**LEVEL III SITE PLAN REVIEW**  
 CONDITIONS OF APPROVAL  
 (See Approval letter dated March 17, 2015 from the City of Portland)

a) **Transportation Standards**

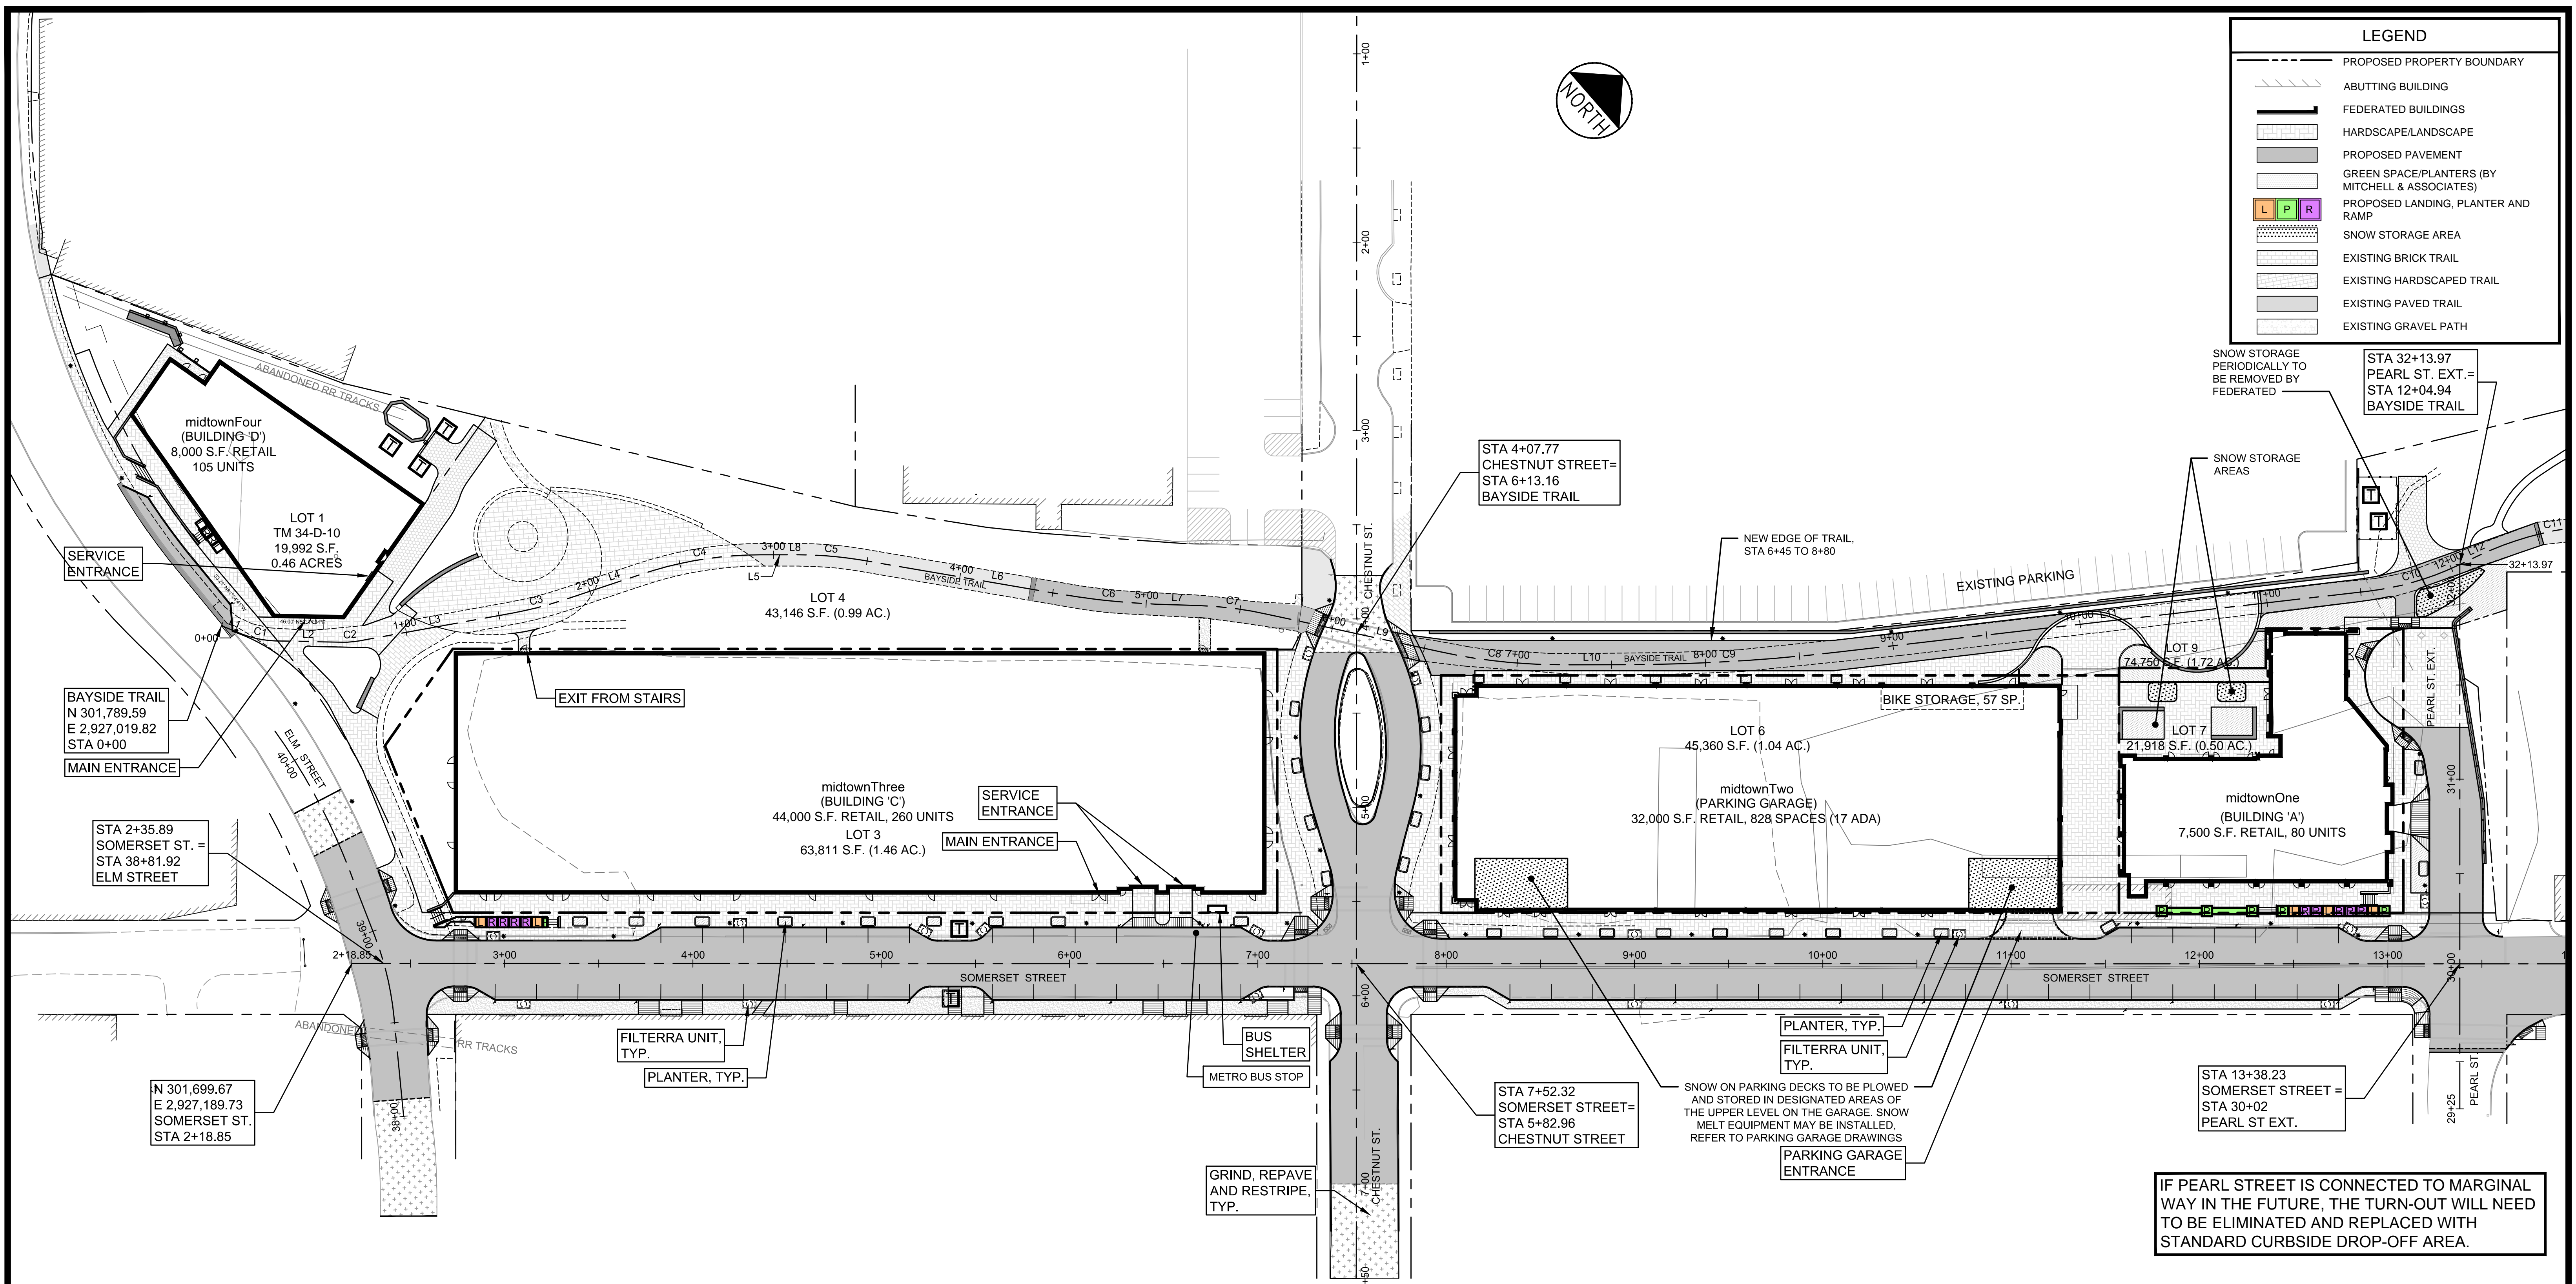
- The configuration of the sidewalk with the indented parking area in front of Midtown 4 will be revised to provide the pedestrian environment along the Elm Street sidewalk. A re-design of this Elm Street frontage is required to comply with the B-7 Design Principles and Standards. Therefore, the on-street parking bay shall be shifted to the south so that it does not constrain the sidewalk in front of building Four. In addition, the sidewalk and cutting must be implemented in a manner that will match an MDOF approved. City plan to modify Elm Street to eliminate that narrow sidewalk at the corner of the Tassier Joe's Building.

- The ramp and landing system on the NE corner of Elm Street - Somerset Street must be revised to achieve ADA compliance and to provide quality pedestrian street crossings and a quality pedestrian environment along Elm Street and Somerset Street. The new configuration is to be reviewed and approved by the Traffic Engineer and Planning Authority.

- The section of sidewalk along Elm Street between Midtown 3 and Midtown 4 does not provide a direct accessible pedestrian route (as depicted on Sheet C-2.08) along Elm Street - the applicant shall provide an updated C-2.08 to show revised pedestrian access routes based on the reconfigured sidewalks and ramps on Somerset Street.

- Portions of the accessible pedestrian route depicted on C-2.08 are not ADA-compliant due to reliance on crossing the flange of a curb ramp and the final plans shall be revised for review and approval - the applicant shall provide an updated C-2.08 to show revised pedestrian access routes based on the reconfigured sidewalks and ramps on Somerset Street.

- Per NFPA 16.7.1.6, Fire Extinguishers
  - Per NFPA 16.7.2, Fuel Systems.
- References to snow storage within the Bayside Trail Corridor shall be removed from all plans and the final management of snow storage submitted for review and approval by the Planning Authority.

**TYPICAL CROSS SECTION
ALONG "PINCH POINT" BEHIND midtown Two (High)**
SCALE: 1" = 4' Horiz., 1" = 8' Vert.

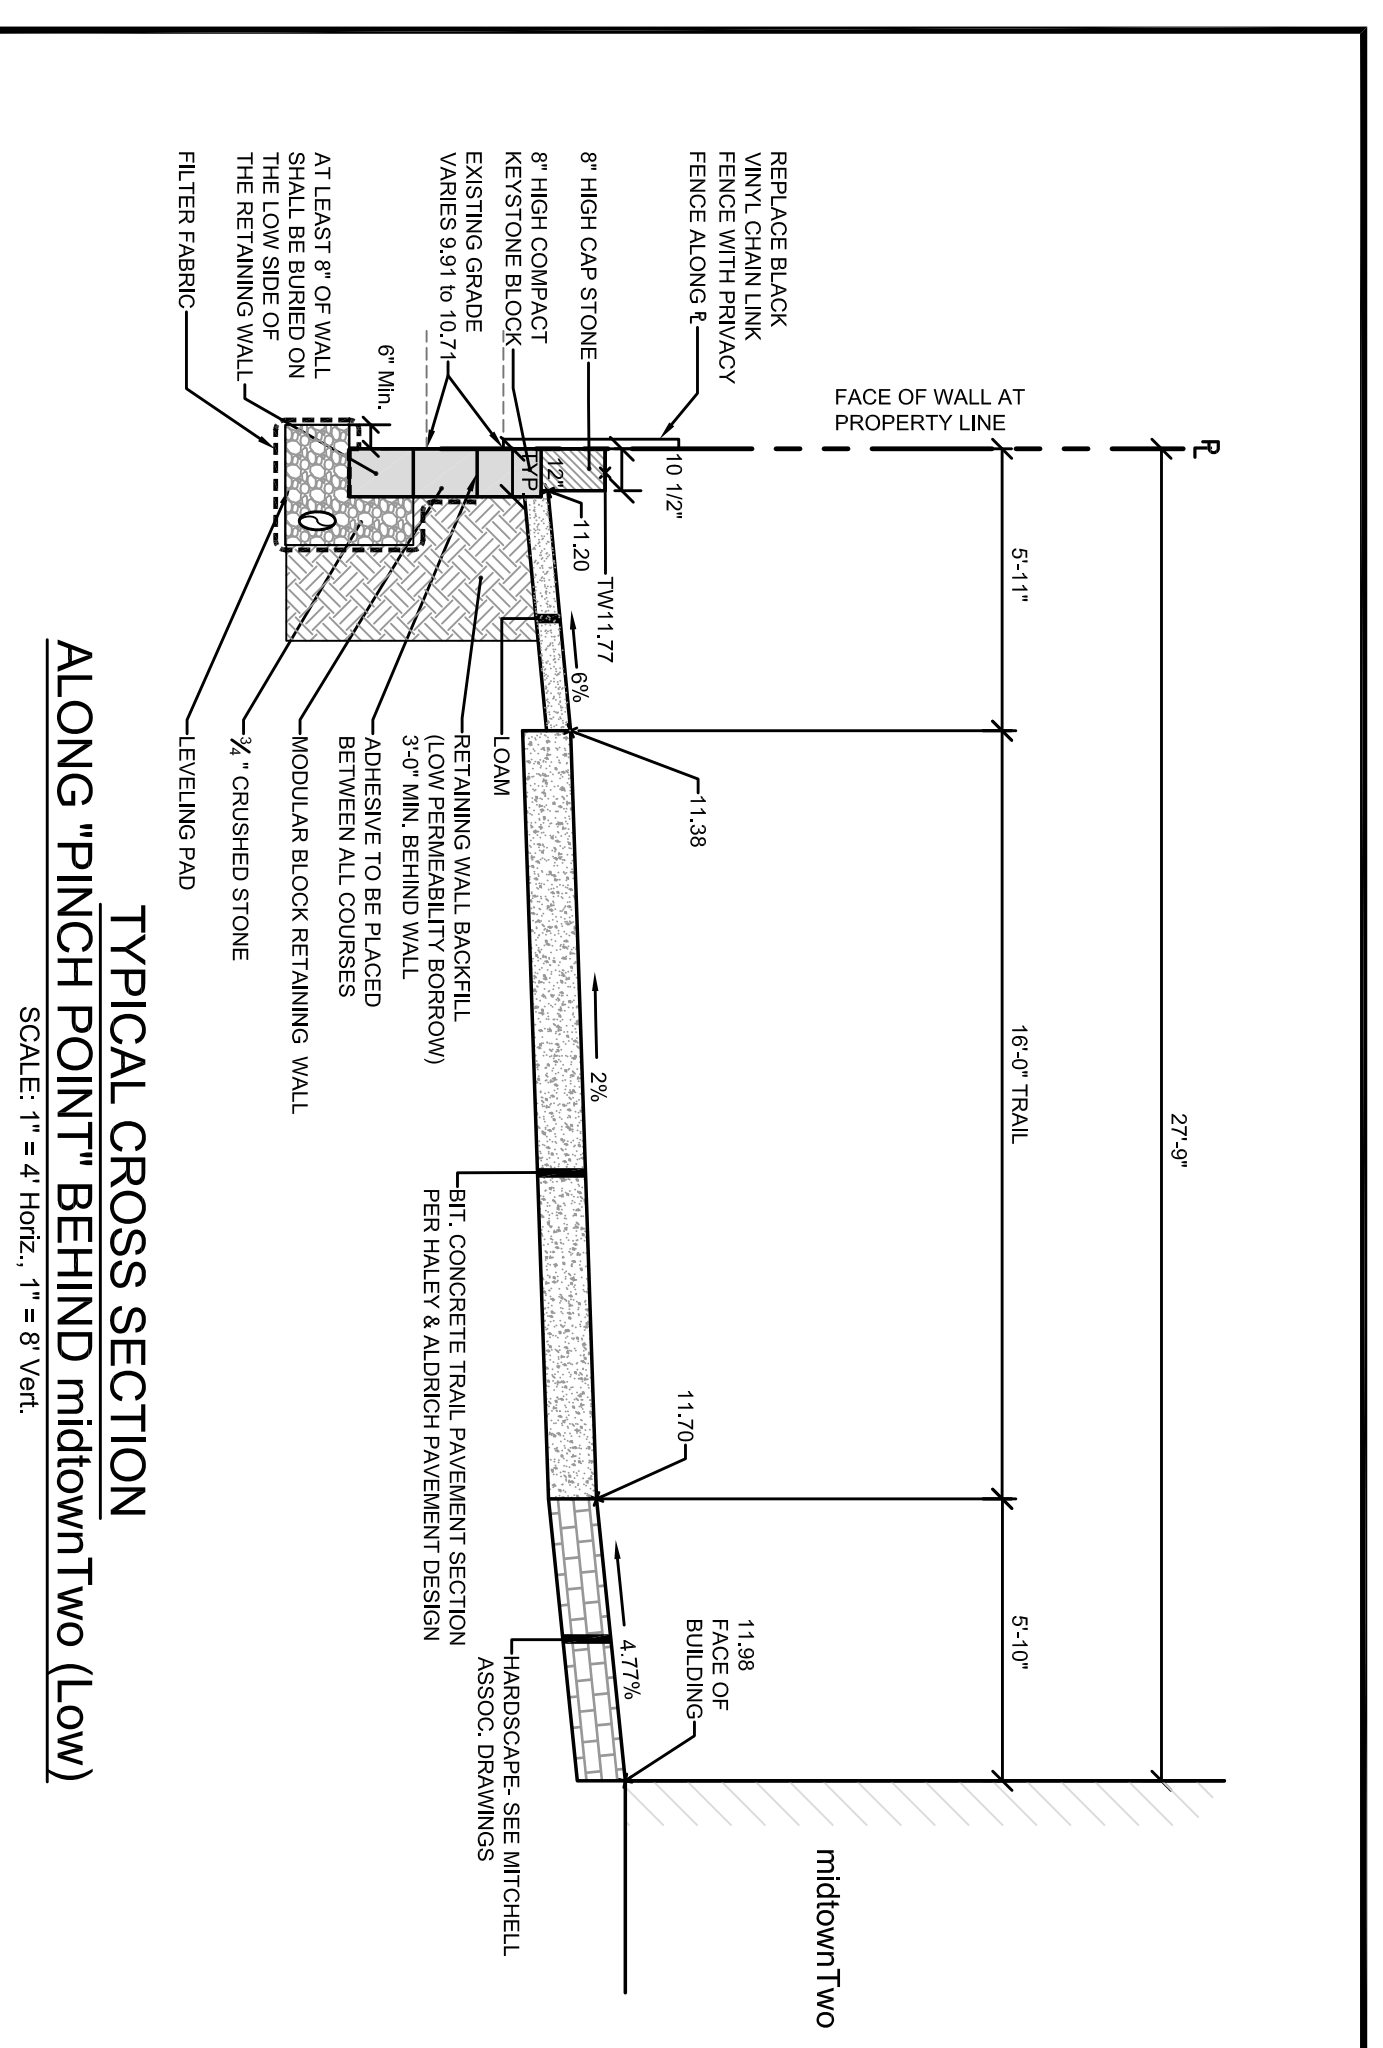
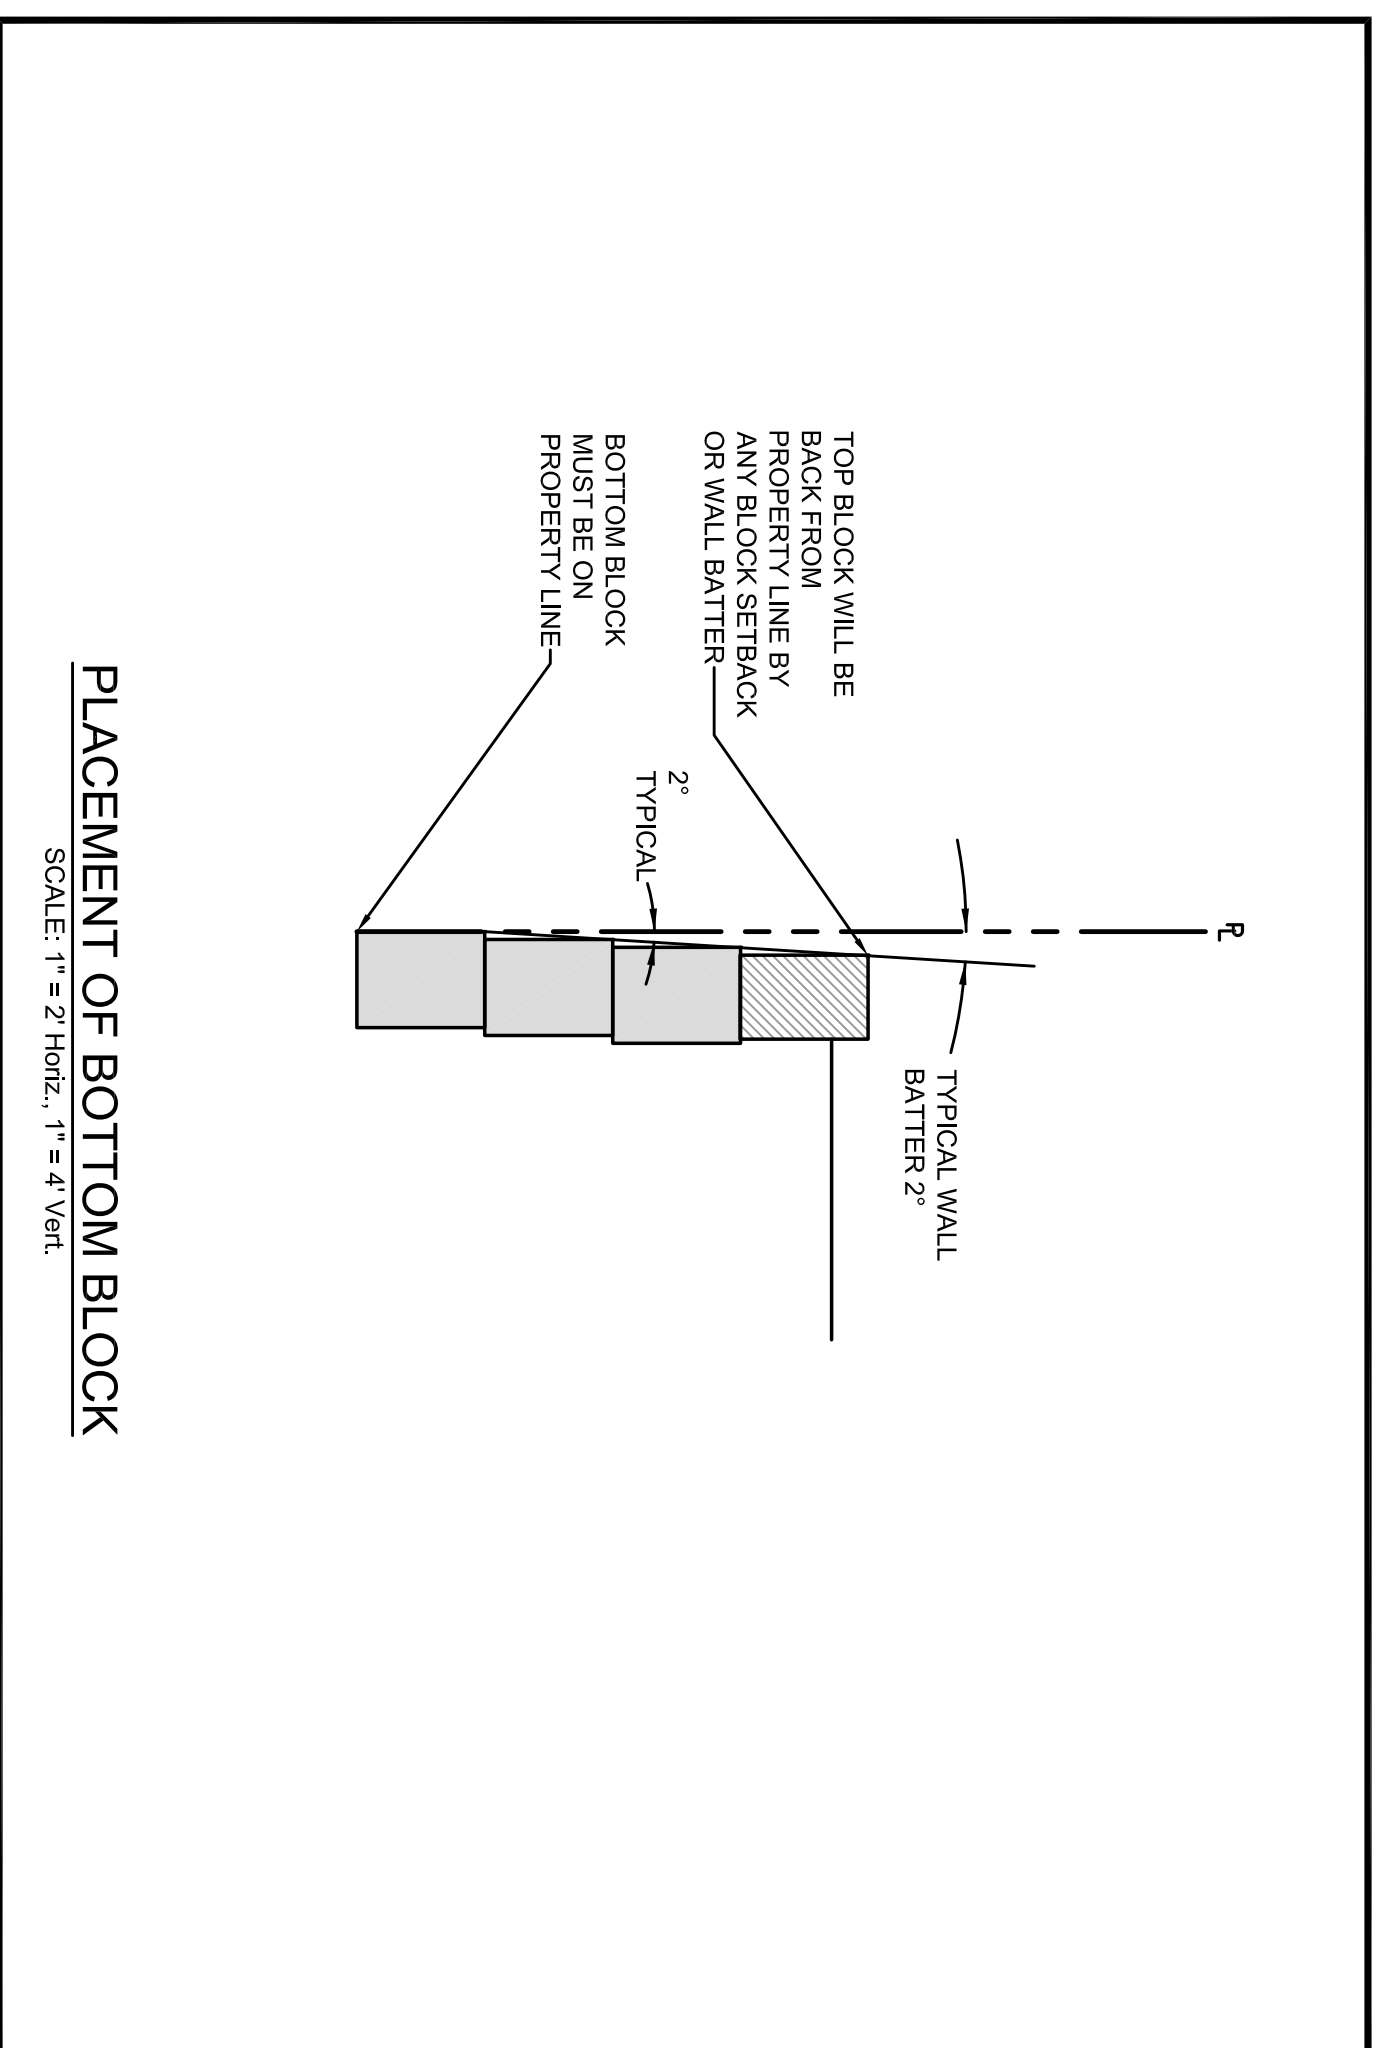
- For the areas behind midtown One and midtown Two, from Bayside Trail STA 6+50 to STA 12+50 (refer to sheets C.0 and C.1.2), the face of the retaining wall and fence as proposed primarily on the property line between City of Portland (Bayside Trail) property and the parcels located north of the Bayside Trail. Temporary construction agreements to abutment for their review and comment, and the applicant shall work together with the City and abutment to coordinate reasonable resolutions to any outstanding details of the street interface with abutting property.
